**RE: Chelwood Apartments  
900 & 901 Chelwood NE  
Grading and Drainage Plan & Drainage Report  
Engineer's Stamp Date: 08/10/19  
Hydrology File: J22D070**

**RE: Chelwood Apartments  
Grading and Drainage Plan & Drainage Report  
Engineer's Stamp Date: 02/06/19  
Hydrology File: J22D070**

Based upon the information provided in your submittal received 02/08/2019, the Grading & Drainage Plan and Drainage Report **is not** approved for Building Permit and Grading Permit. The following comments need to be addressed for approval of the above referenced project:

ENGINEER'S SEAL DAVID SOULE 14522 REGISTERED PROFESSIONAL ENGINEER	CHELWOOD APARTMENTS	DRAWN BY WCVJ
	GRADING AND DRAINAGE PLAN	DATE 6-18-19
		218149-LAYOUT-6-18-19
		SHEET #
		JOB # 218149

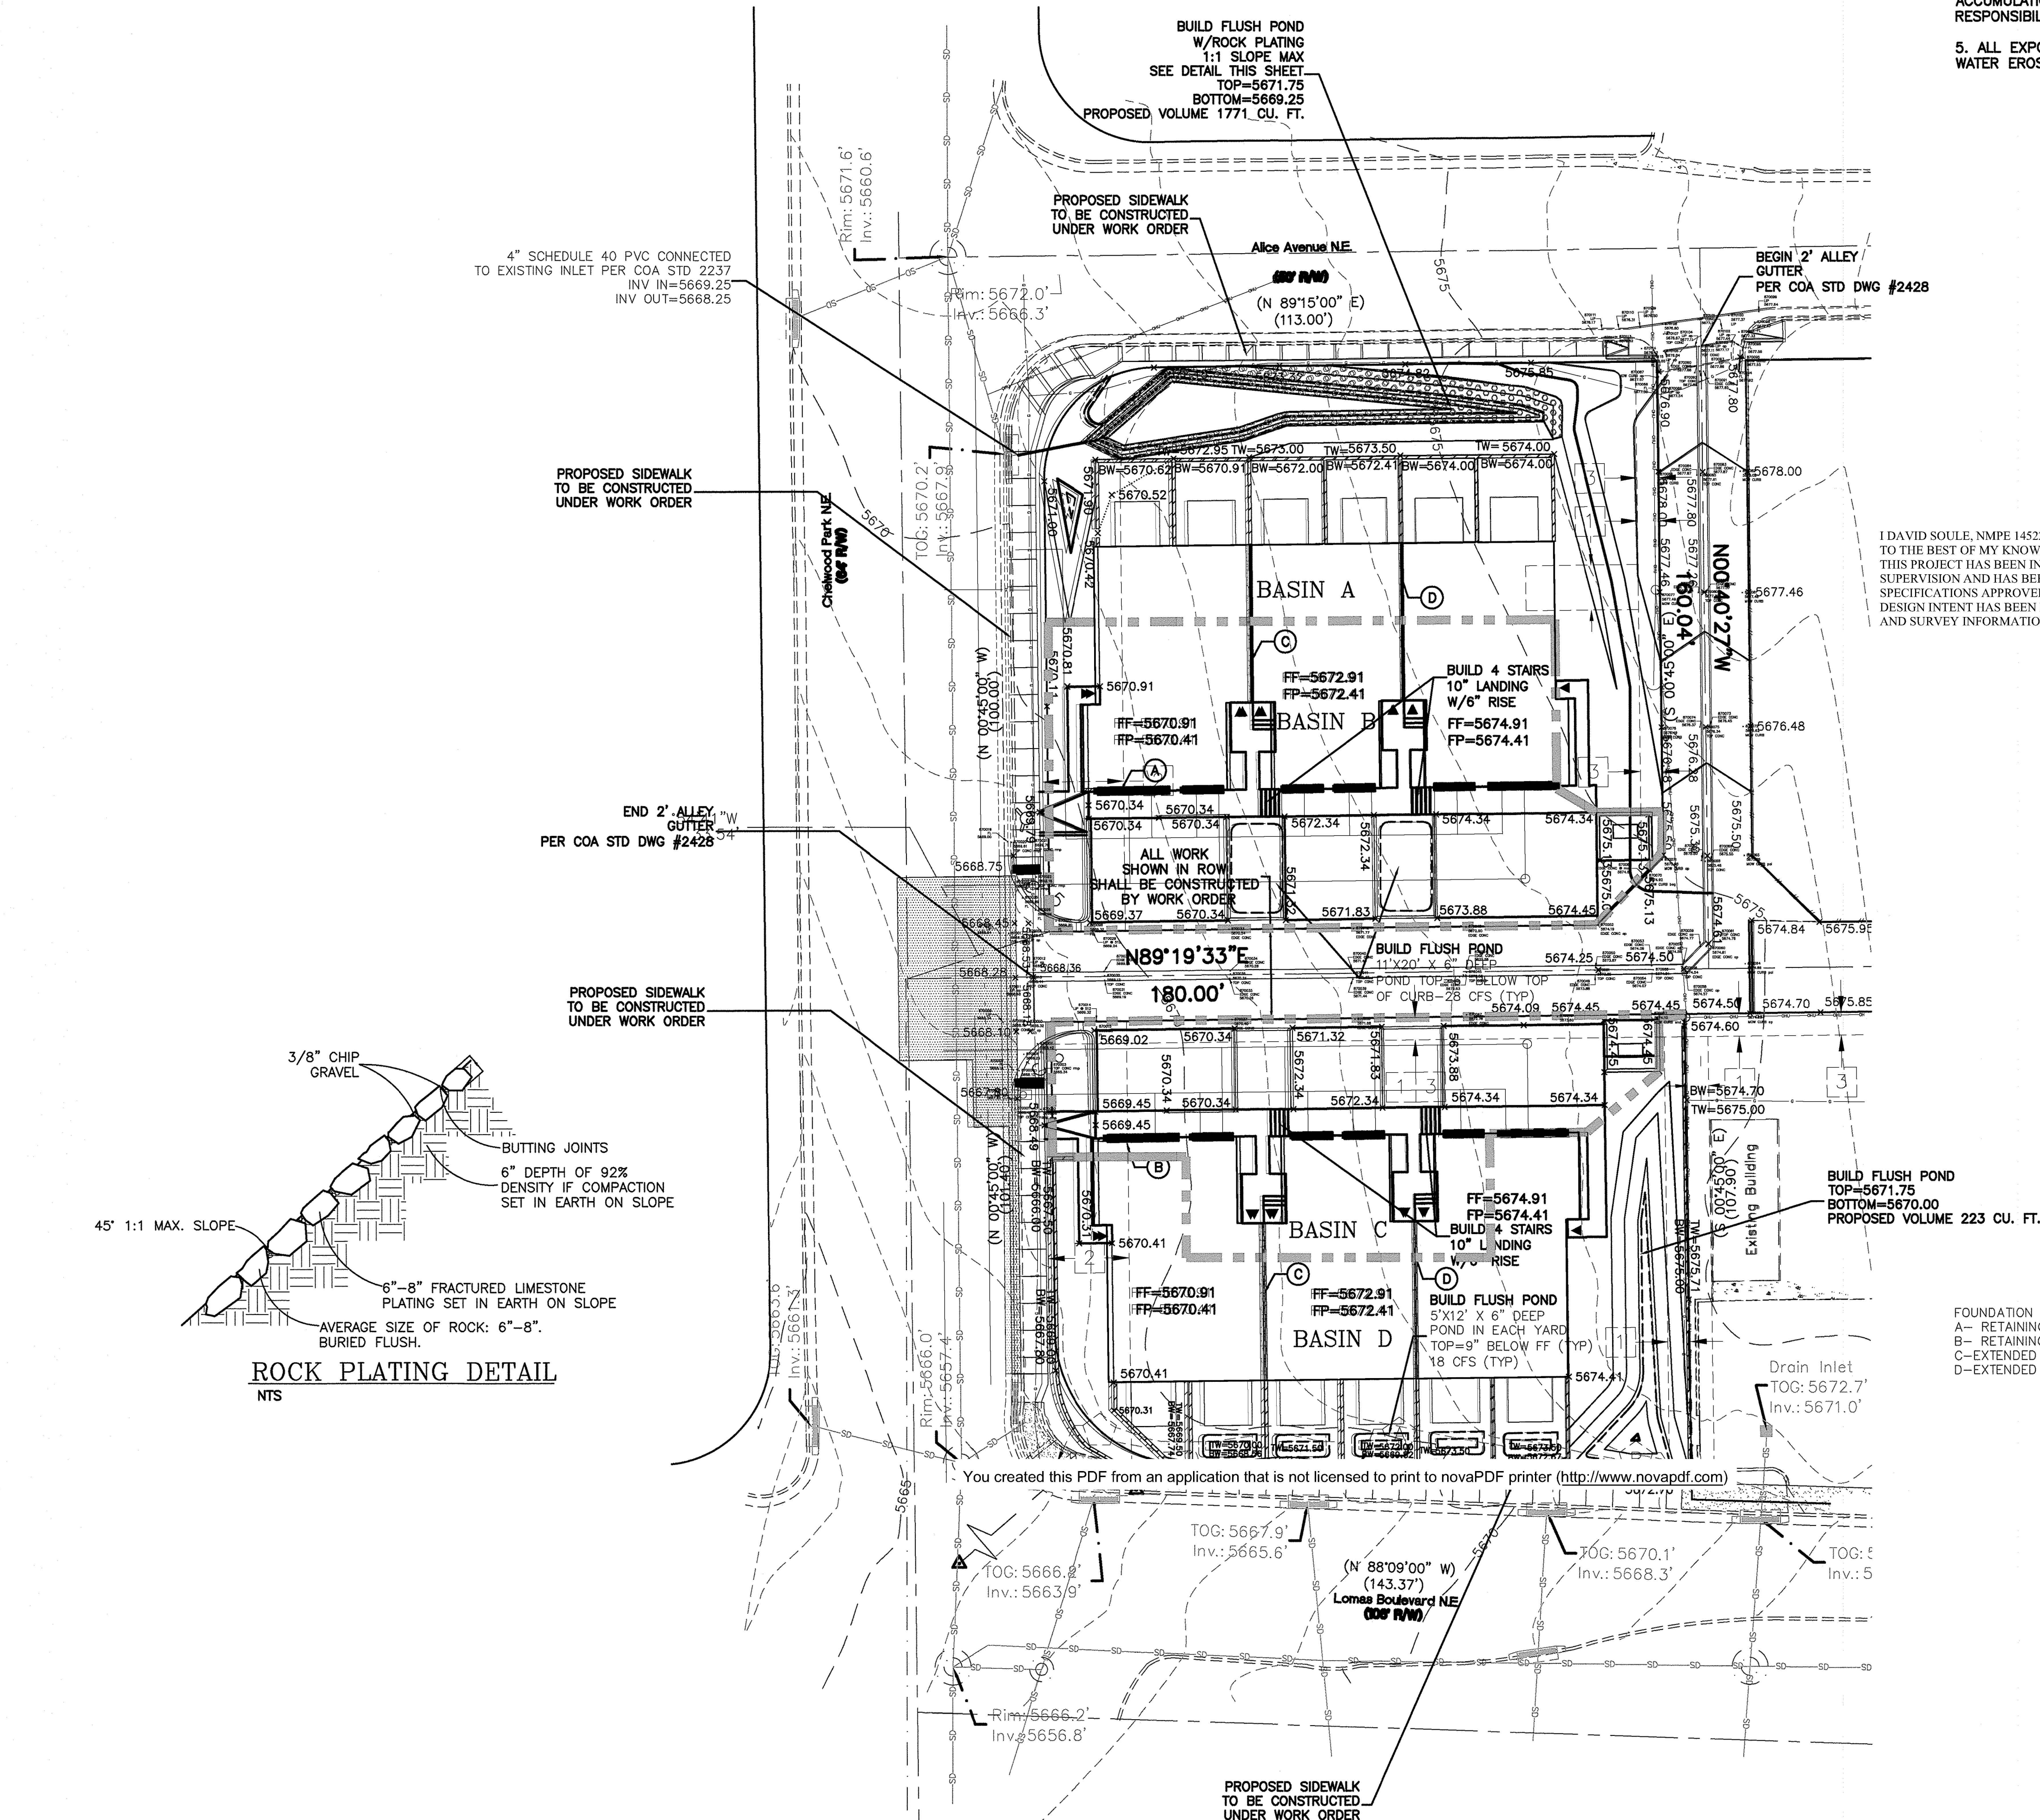
4. Please label the proposed sidewalks and improvements within the two alleys to be built with a work order. **added labels**
5. Please check with Transportation if the existing asphalt sidewalk along Lomas needs to be replaced to City standards. **we have identified this as to be constructed**

6. Please add a typical section through the ponds at Chelwood Park showing the R.O.W., existing road payment, proposed sidewalk, proposed retaining wall with the location of the footer (see comment #7), and the proposed building. **section added**

7. Per DPM Ch. 22.5.B, grading and construction of retaining walls at or near the property line must demonstrate that the adjacent property is not damaged or its use constrained. Any such encroachment by the wall within the City's R.O.W. must be accompanied by a licensing agreement. **section and language regarding this comment has been added**

8. Please show the alley gutter per City Drawing #2411 & 2415. Grading within the alleys must also follow these standard drawings. **added notes**
9. Please show the flowline elevations of the alley gutter at the ends where it will tie into existing grades and at the intersection of the two alley gutters. **added spots**

10. Are there emergency spillways for the overflow of the two ponds along Chelwood Park to enter into the street curbing through sidewalk culverts? Or is the piping into the existing inlets have sufficient capacity for the overflow? Please verify. **we understand emergency spillways are allowed to pass over sidewalks**

11. Some of the callouts are in different text shading. Please ensure that all proposed callouts are the same. **we have cleaned up the text shading differences**
